**Pacific Brook Christian School, Muswellbrook (SSD-16858710)
Response to Submissions**

ATTACHMENT 1

Note: This map presents the maximum depths and levels for the MC2 (Golf Course Flood Bund) development scenario

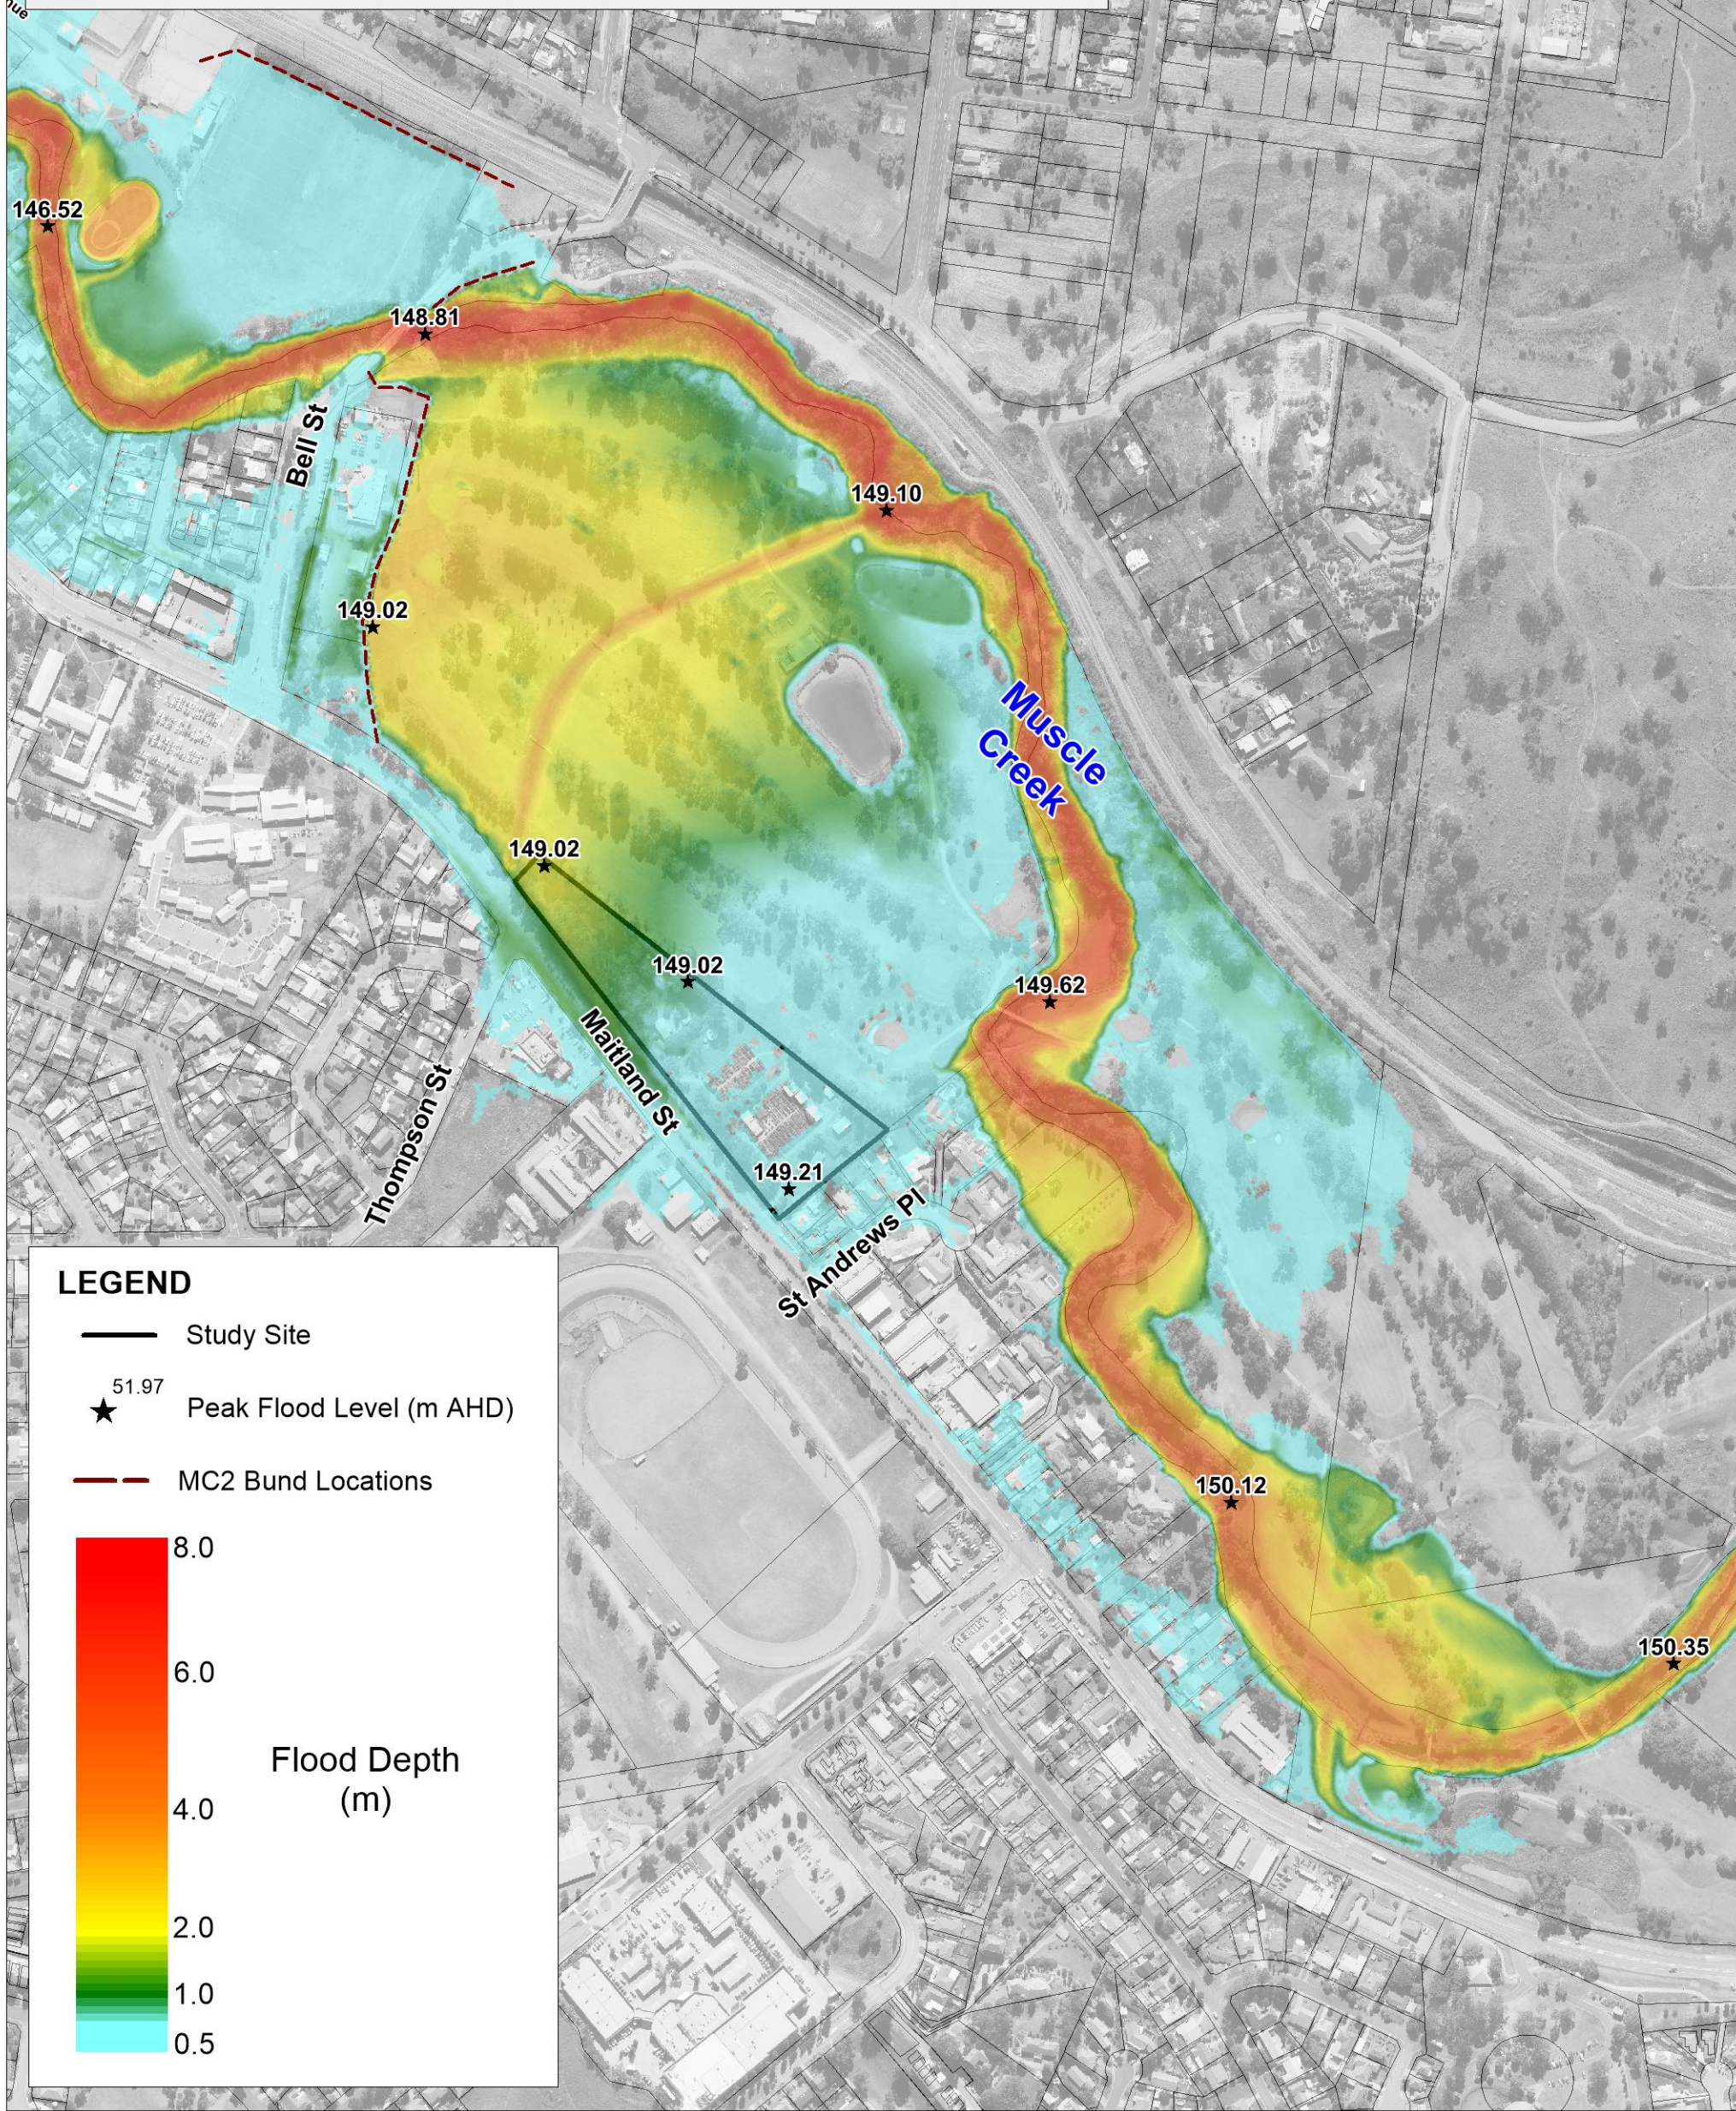
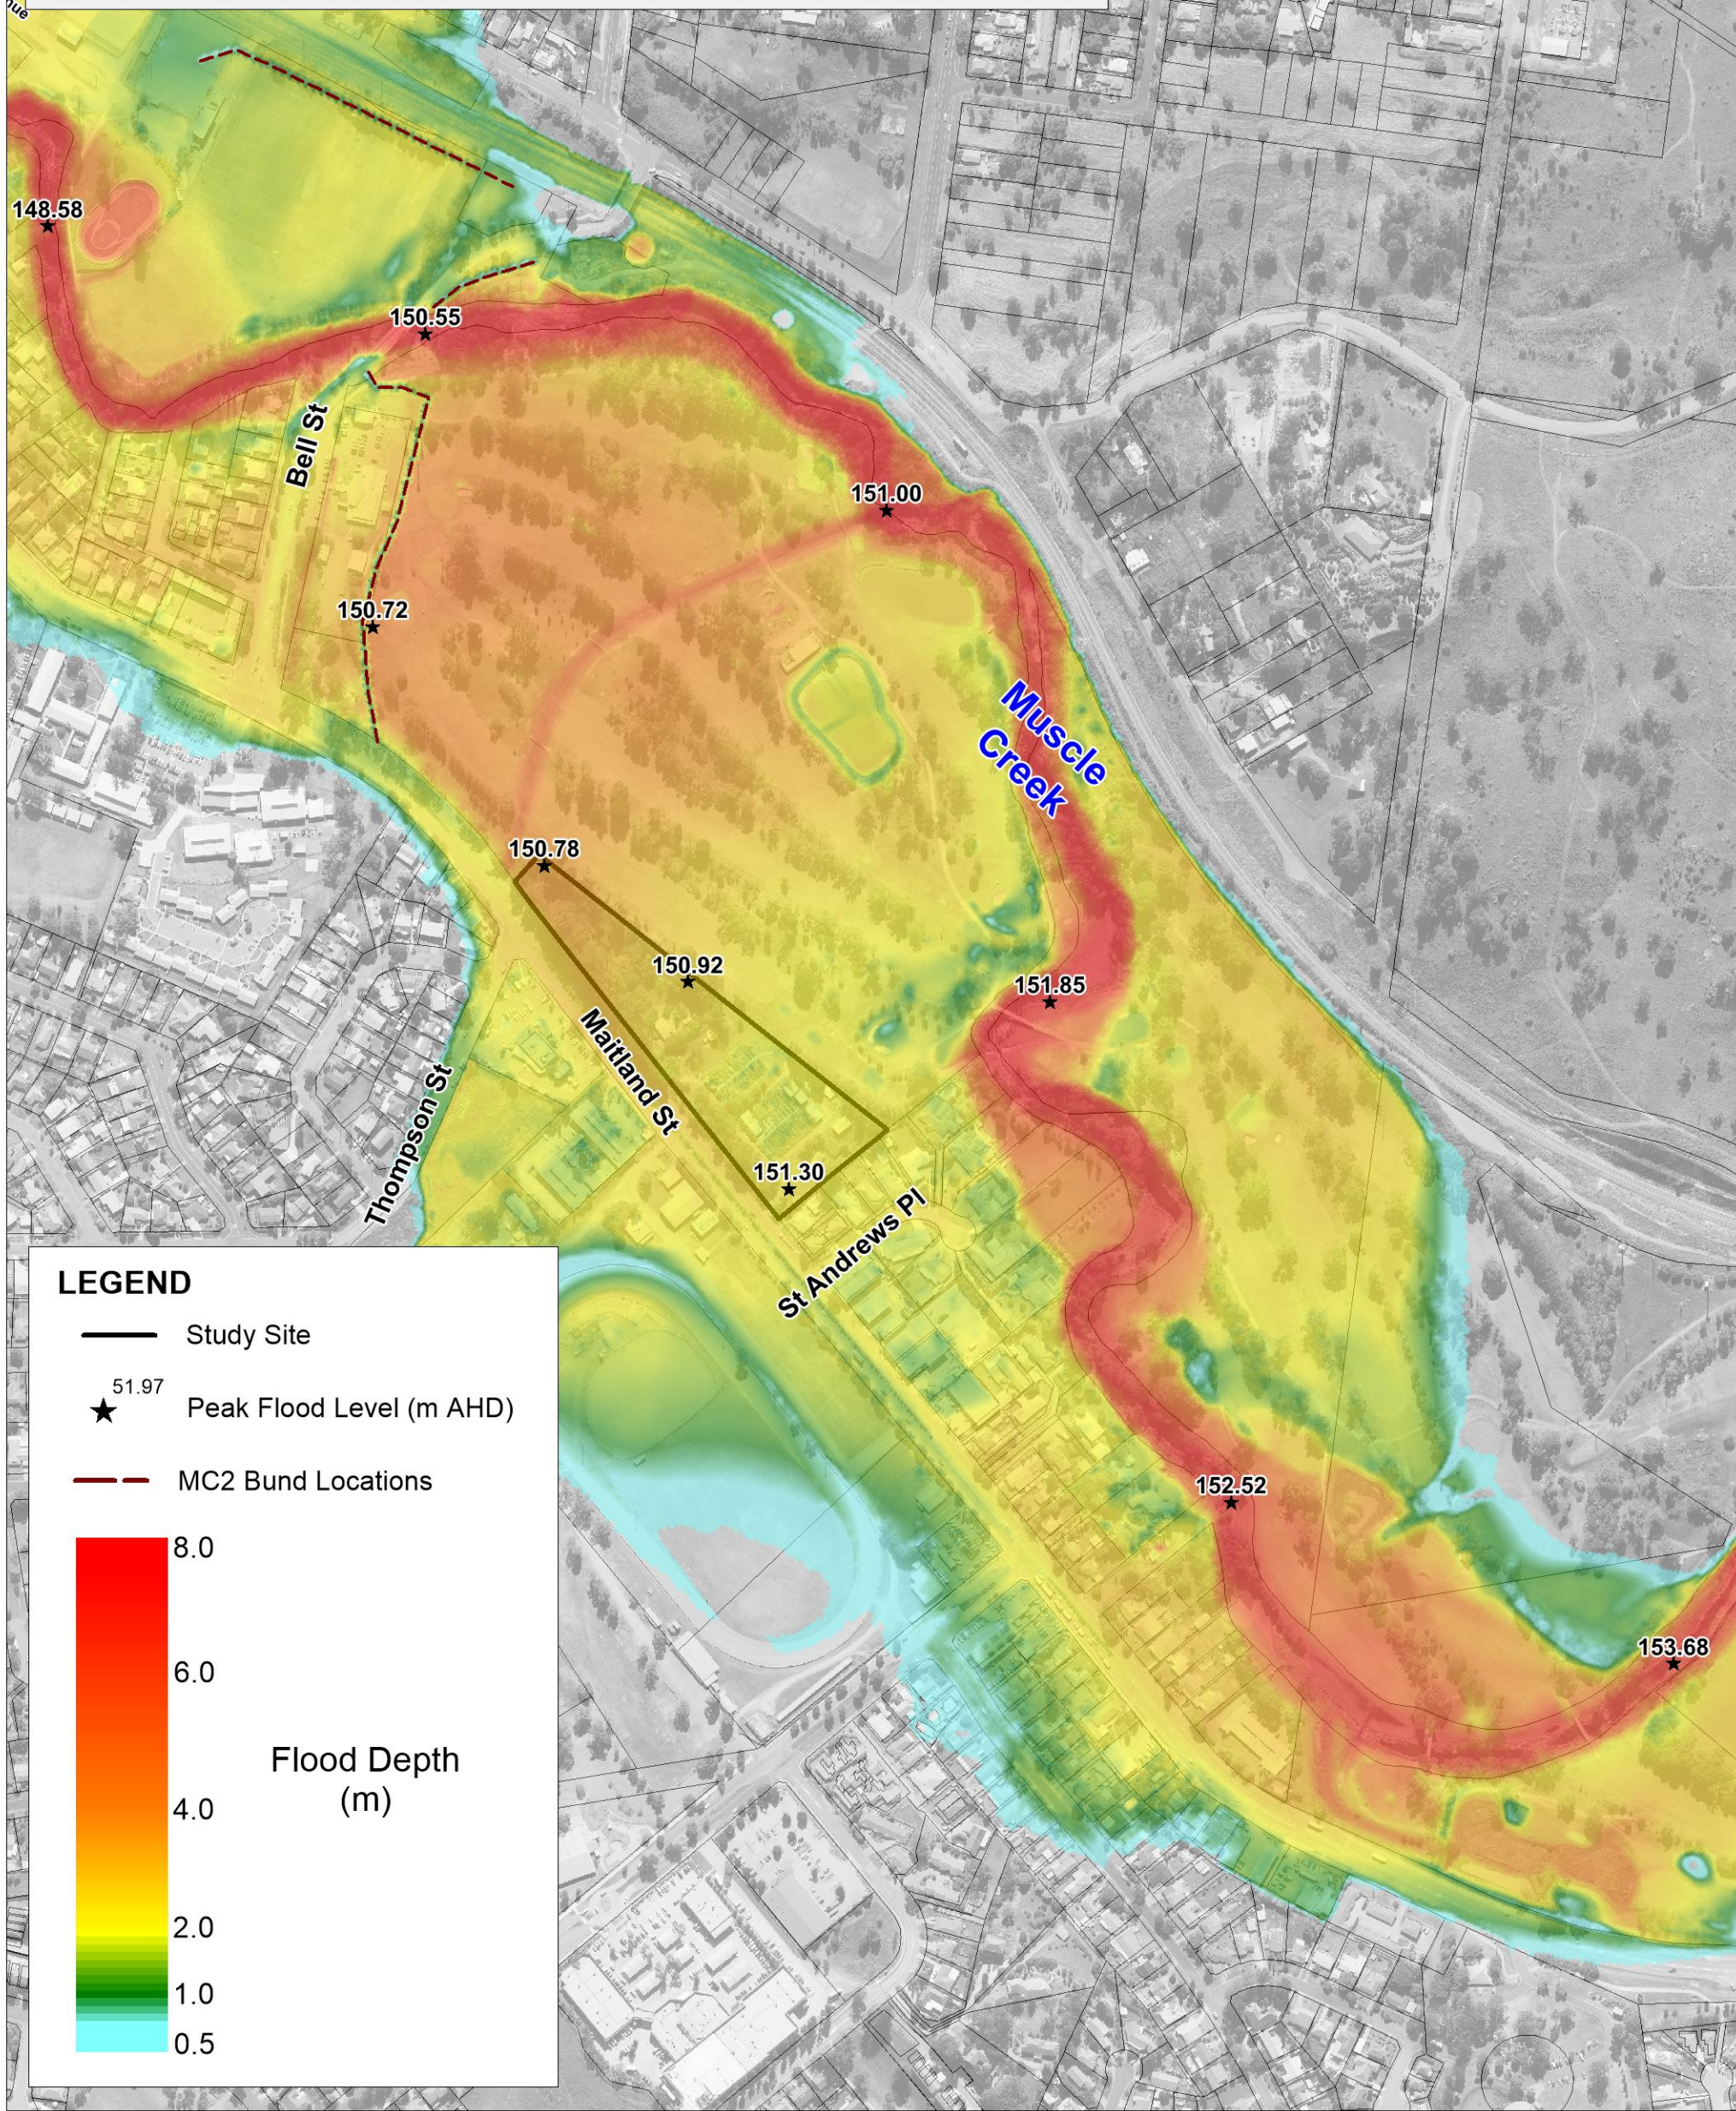
- Biodiversity and Conservation Division (BCD) have reviewed the proposal and raised substantial concerns with regard to flooding within the site. The Department shares the concerns of the BCD and requests that you amended your flooding report and respond to the comments raised by BCD.
- Additionally, the potential effects of climate change, sea level rise and an increase in rainfall intensity has not been adequately assessed. Please provide a more comprehensive flood assessment which addressed these impacts.
